FIRE RISK MANAGEMENT, INC

Memo Report

Subject: Fire & Life Safety Evaluation of 98 Washington Ave. in Portland, ME

98 WASHINGTON AVE
 98 1st Floor Proposed
 (office in rear, food service in front)

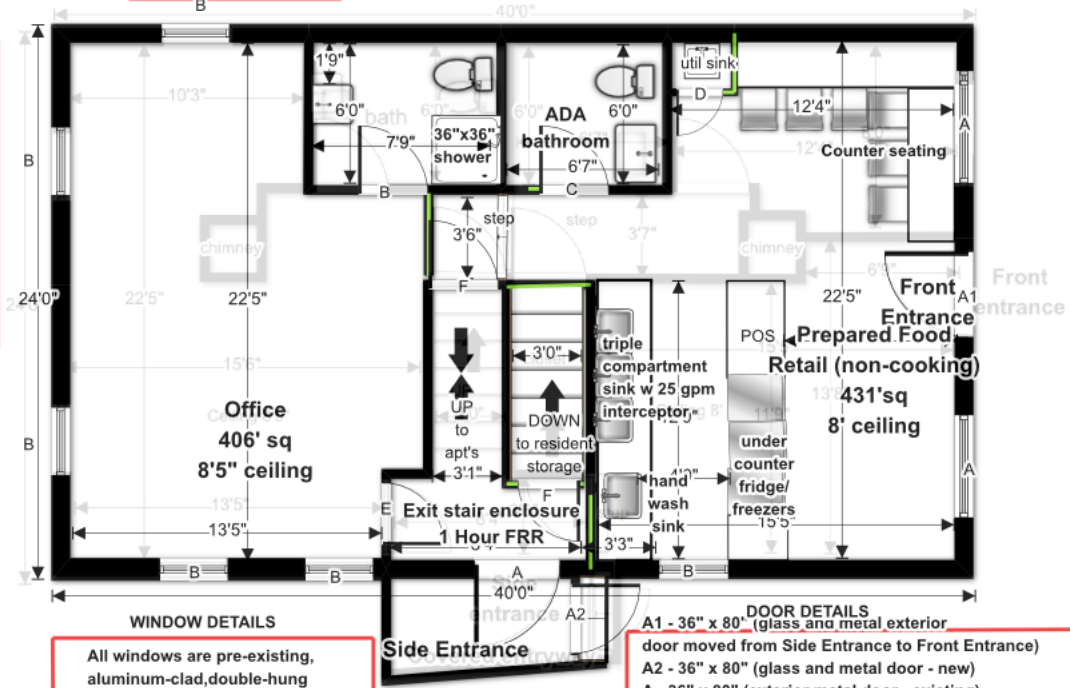
The building is to be provided with two (2) primary exits at the 1st floor level; one on the east side of the building, leading from the proposed Mercantile space, and a second on the south side of the building, which serves as the exit for the enclosed stairway and also serves as the exit from the Business occupancy on the west end of the building. If these exit doors consists of at least a “standard” 36-inch door that provides approximately 34 inches of clear width, they would each have the capacity to accommodate up to at least 170 persons; using the standard exit capacity factor of 0.2 in./person from NFPA 101. Therefore, the building has more than sufficient exit capacity to accommodate the expected maximum occupant load.

The codes typically require that each story and all areas within a building be provided access to at least two means of egress. Although the 1st floor area indicates that the mercantile and business portions of the floor are connected via an open hallway, due to the expected occupant loading of each, and the fact that each has direct access to an exterior exit door, a single exit would be allowed for each of these areas and if desired, they could be separated from one another.

SEPARATION AND STC DETAIL  
98 WASHINGTON AVE

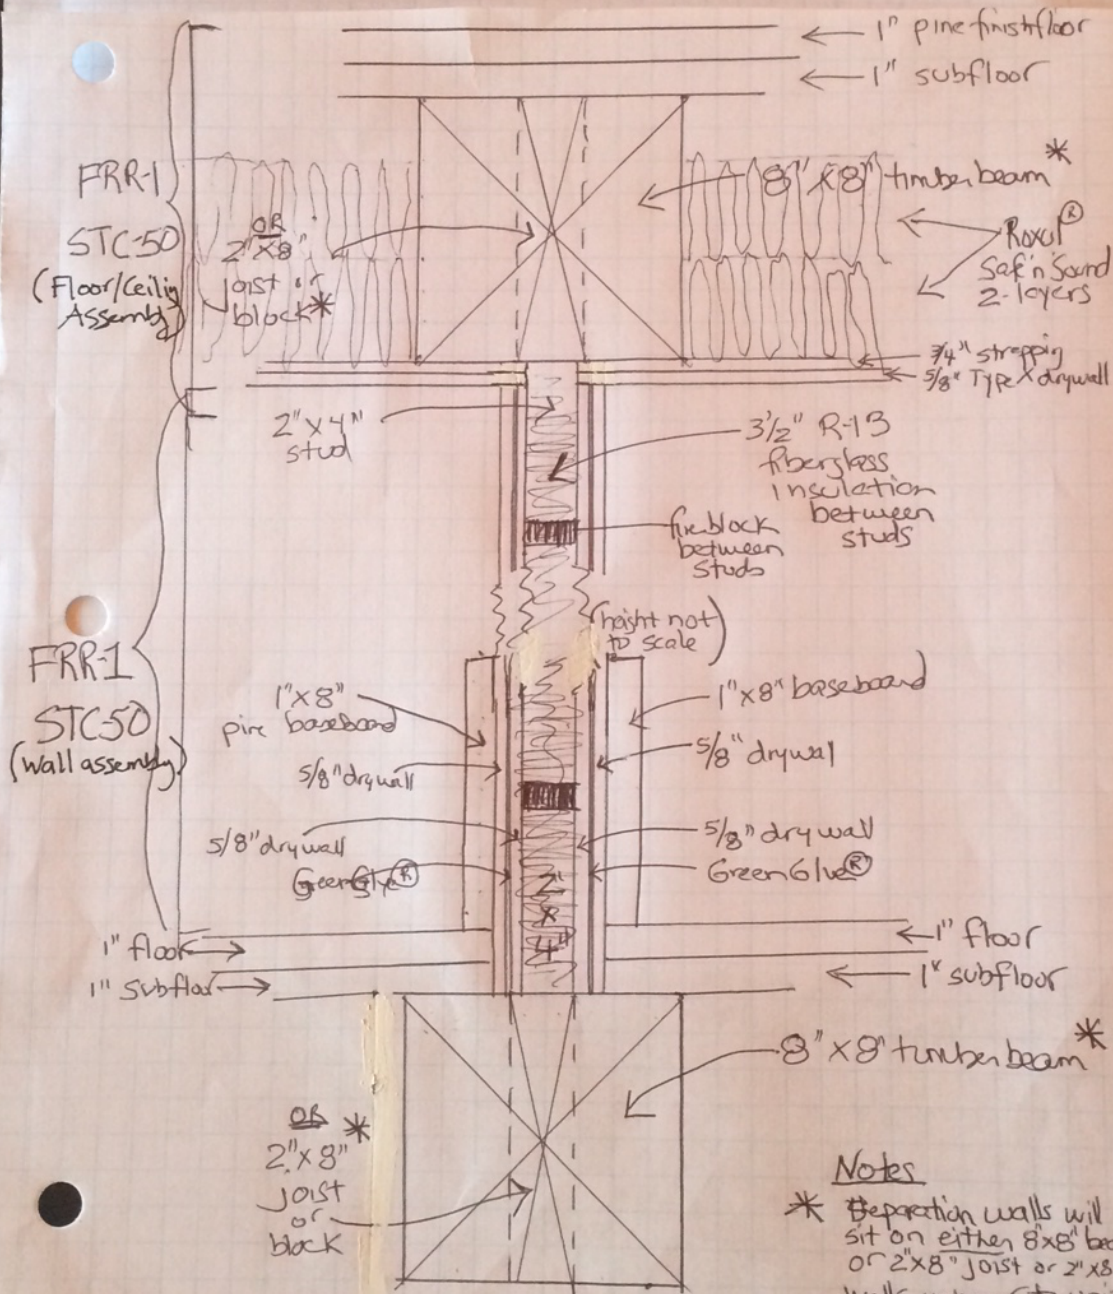
Even if the building were to be classified as a non-separated mixed use occupancy, based on its existing size (area and height), construction type (whether Type IIIB or Type IV), and the fact that a fire sprinkler system is to be installed, it will easily comply with the height and area limitations outlined in the IBC for any of the occupancies planned for inclusion in this building's use. In addition to the separation requirements between the Residential and other occupancies, the individual apartments must be separated from one another by barriers having at least a ½-hour FRR.

- c. ½-hour FRR for all walls and floor/ceiling assemblies separating individual dwelling units. Use of standard wall and floor/ceiling construction materials should be adequate; albeit all penetrations in these barriers must be properly protected/sealed.
